**KIRKLEES METROPOLITAN COUNCIL
INVESTMENT & REGENERATION SERVICE**

Reference No:	2024/62/92912/W
Site Address:	31, Stafford Hill Lane, Kirkheaton, Huddersfield, HD5 0EE
Description:	Demolition of existing garage and erection of 2 storey side and rear extension
Recommending Officer:	Joshua Merriman

HOUSEHOLDER DELEGATED REPORT

Existing & Proposed front and rear elevations			
31 Stafford Hill			
Kirkheaton			
Huddersfield			
HD5 0EE			
Date	Oct 24	Dwg no	03 A
Dwn By		Scale	A3 - 1:100

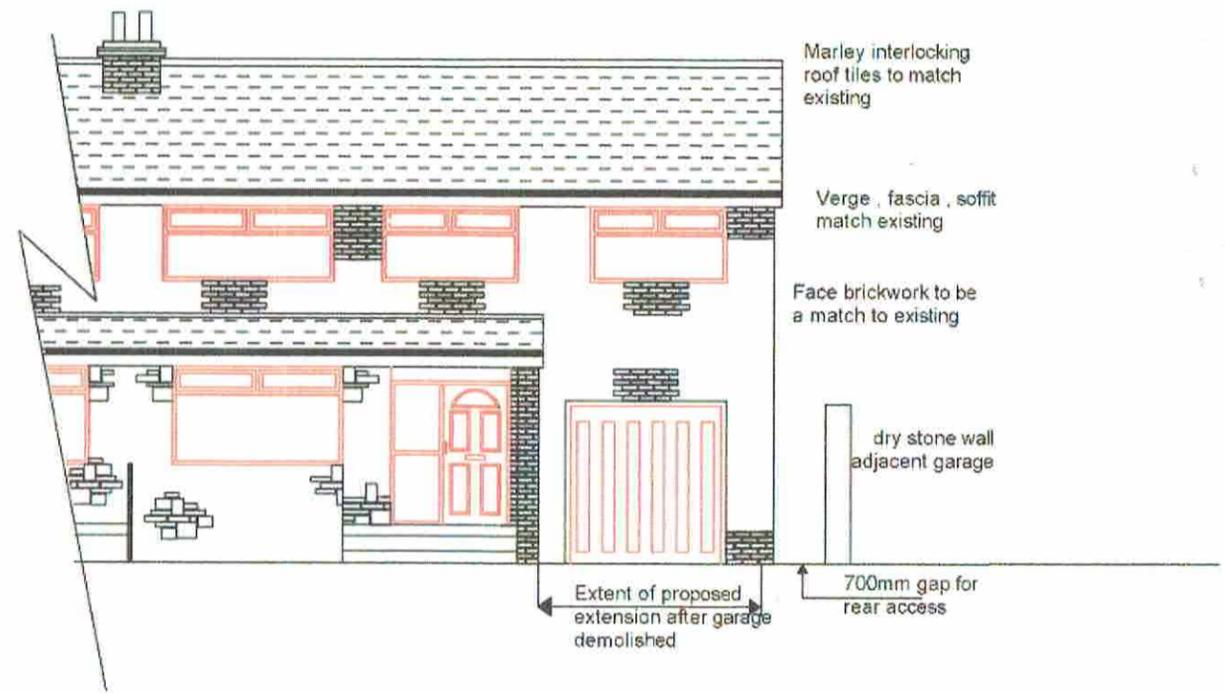
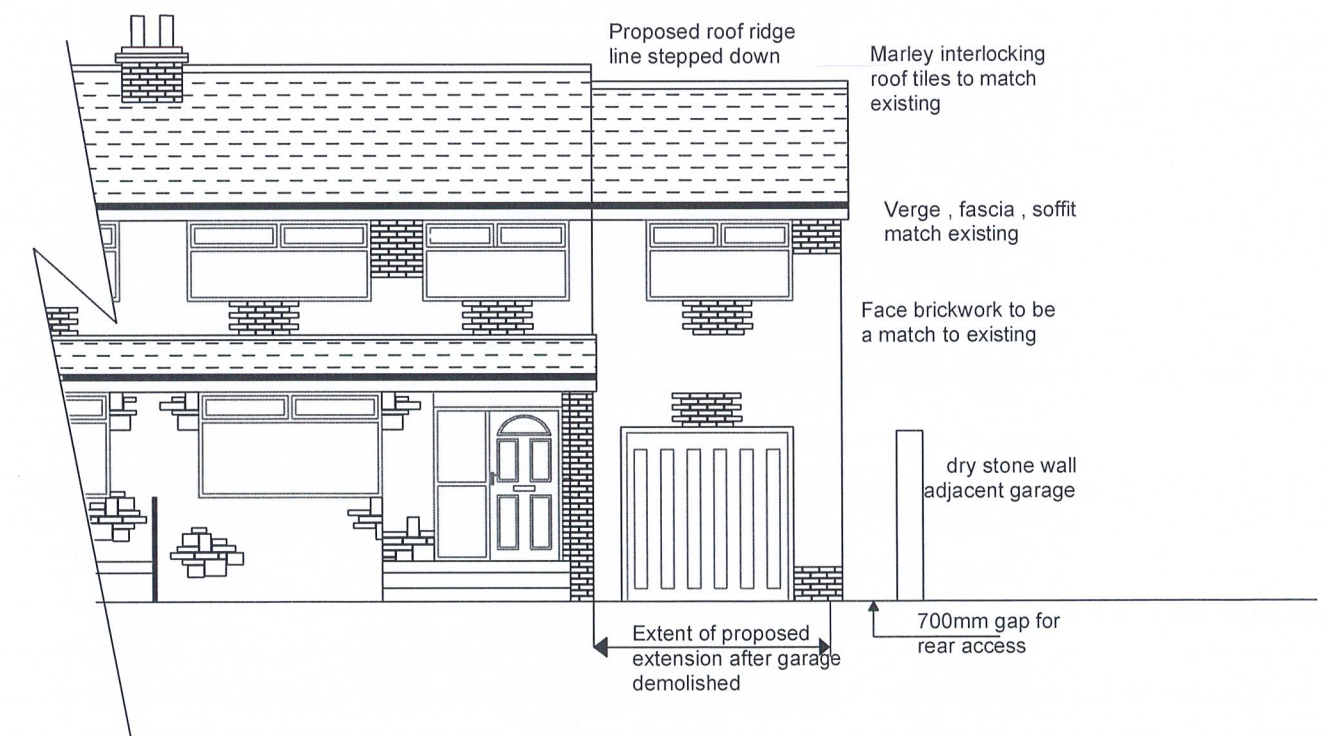
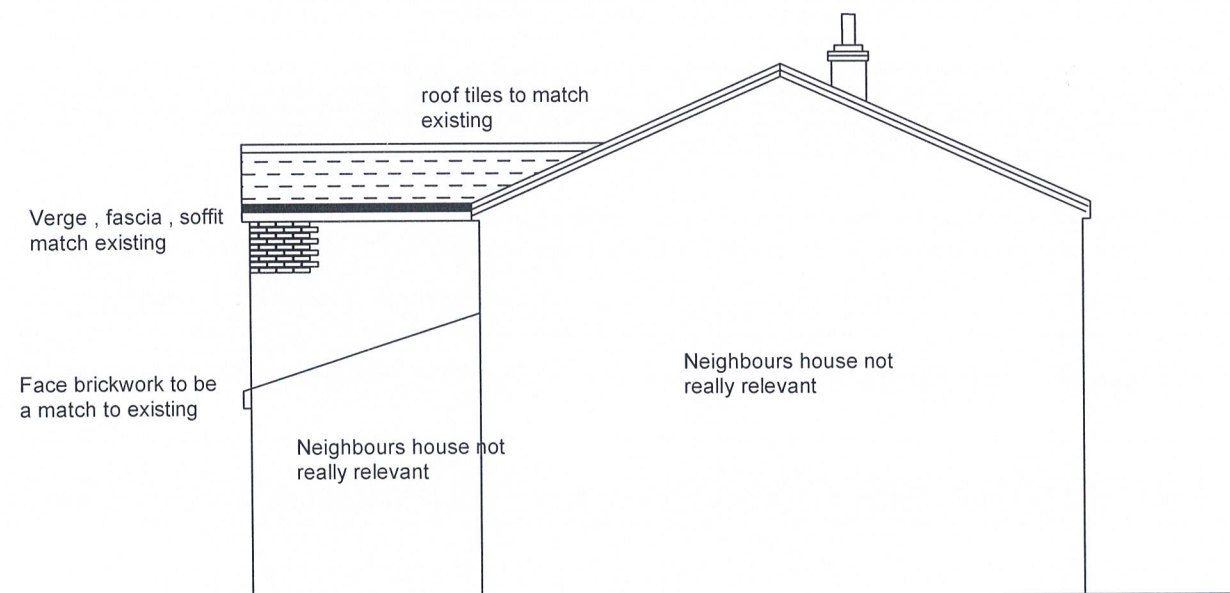
YES / NO	SUMMARY
Negotiations/Amendments during course of application	Yes	It was requested that the side extension was set back 500mm from the front elevation of the existing building, and set down from the existing roofline of the original property. These requests were fulfilled with newly submitted plans.
Parish/Town Council comments sought	Yes	Kirkburton Parish Council have been consulted regarding the application, but offered no comments.
Planning History	No

be set back at least 500mm from the front wall of the house	The proposed extension is set back 500mm from the front elevation of the existing property.

Proposed First Floor

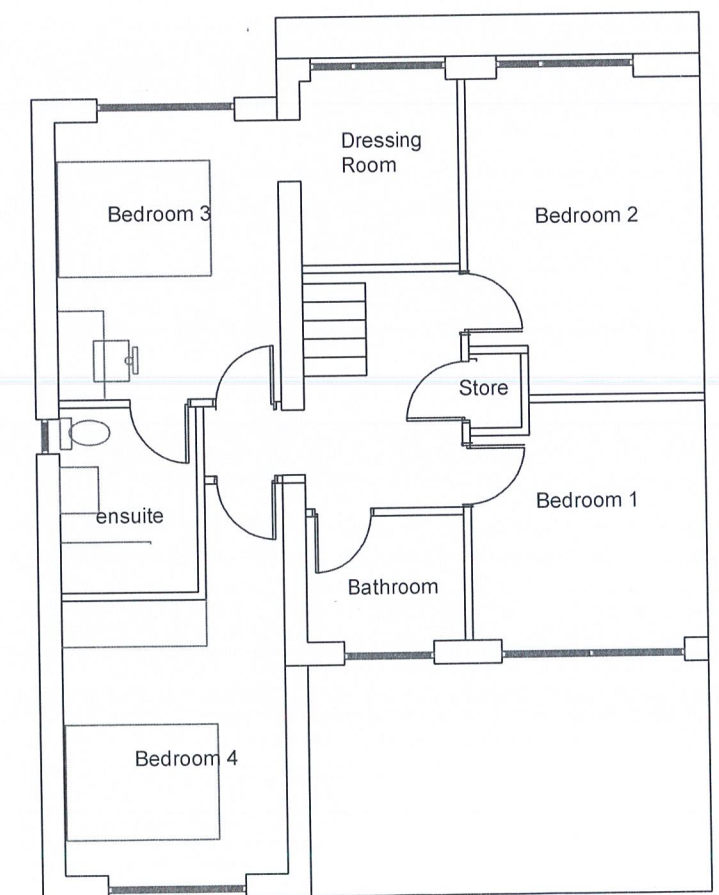
3. The first floor window in the Southeast elevation shall be fitted with obscure glazing to at least Level 3 on the Pilkington Scale (or equivalent) and be non-opening to a height of no less than 1.7m above floor level and retained as such thereafter.

Existing & Proposed Rear and Side Elevations 31 Stafford Hill Kirkheaton Huddersfield HD5 0EE			
Date	Oct 24	Dwg no	02 A
Drawn By	-----	Scale	A3 - 1:100

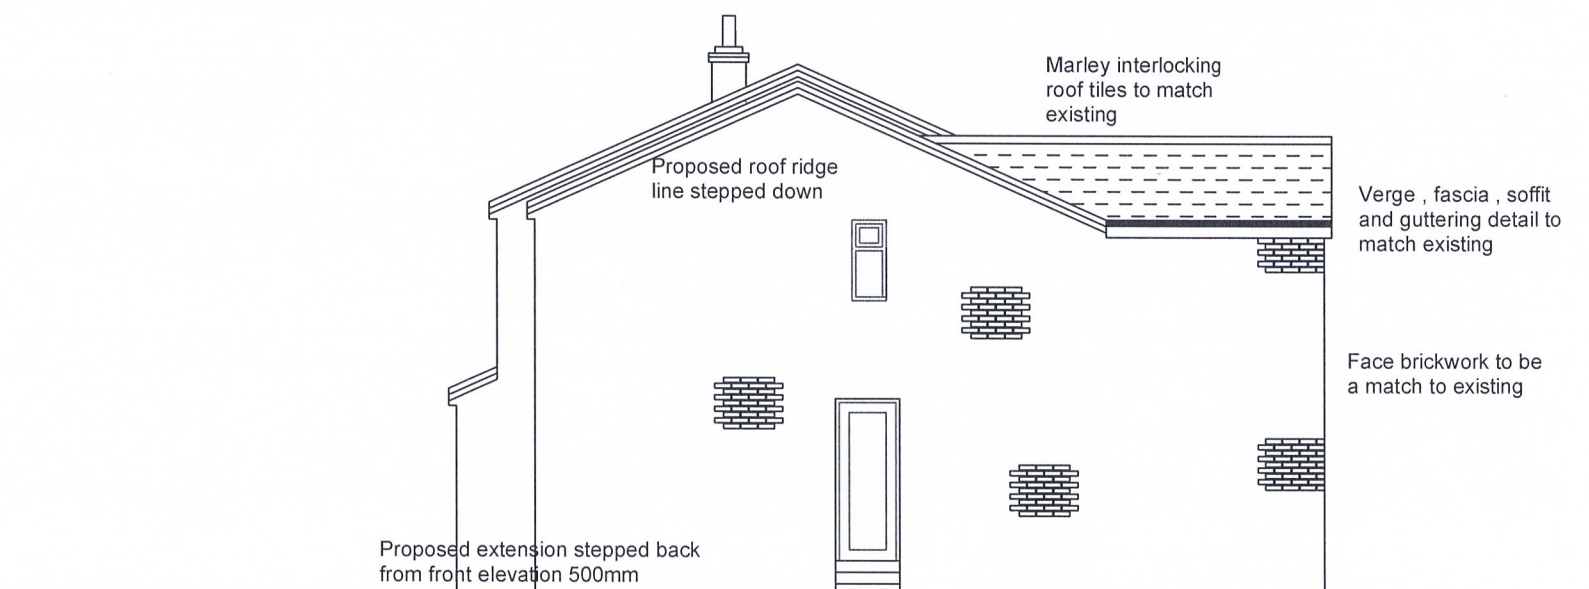
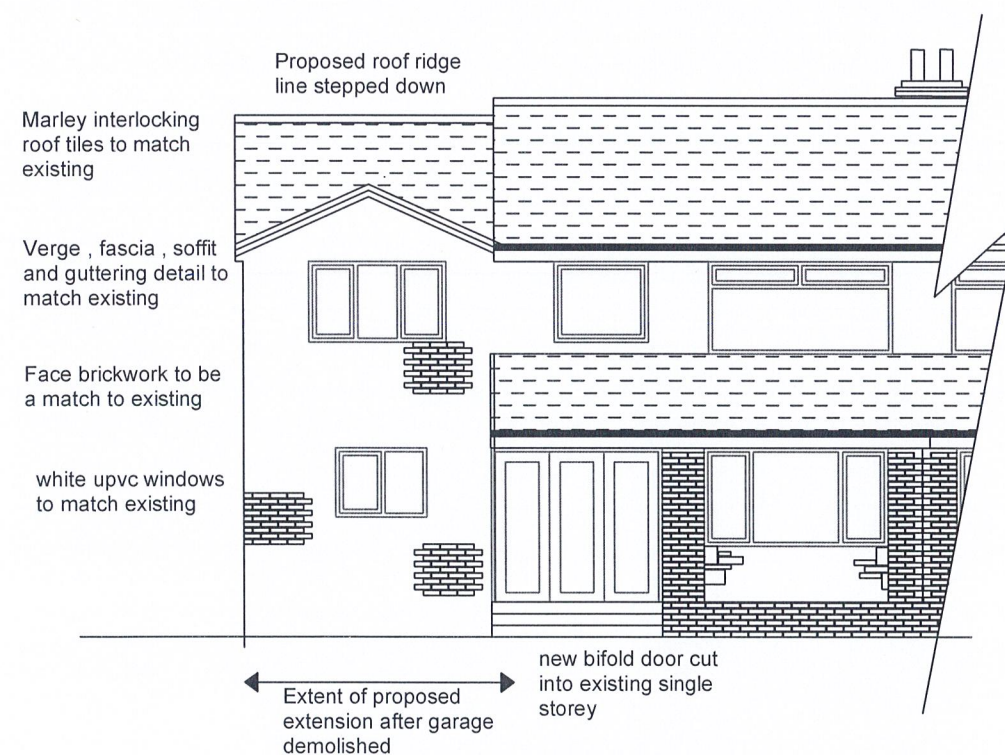
The proposed side extension will project 3.23m from the side elevation of the original dwelling, with a maximum height of 6.82m, an eaves height of 4.97m, and a depth of 10.4m.
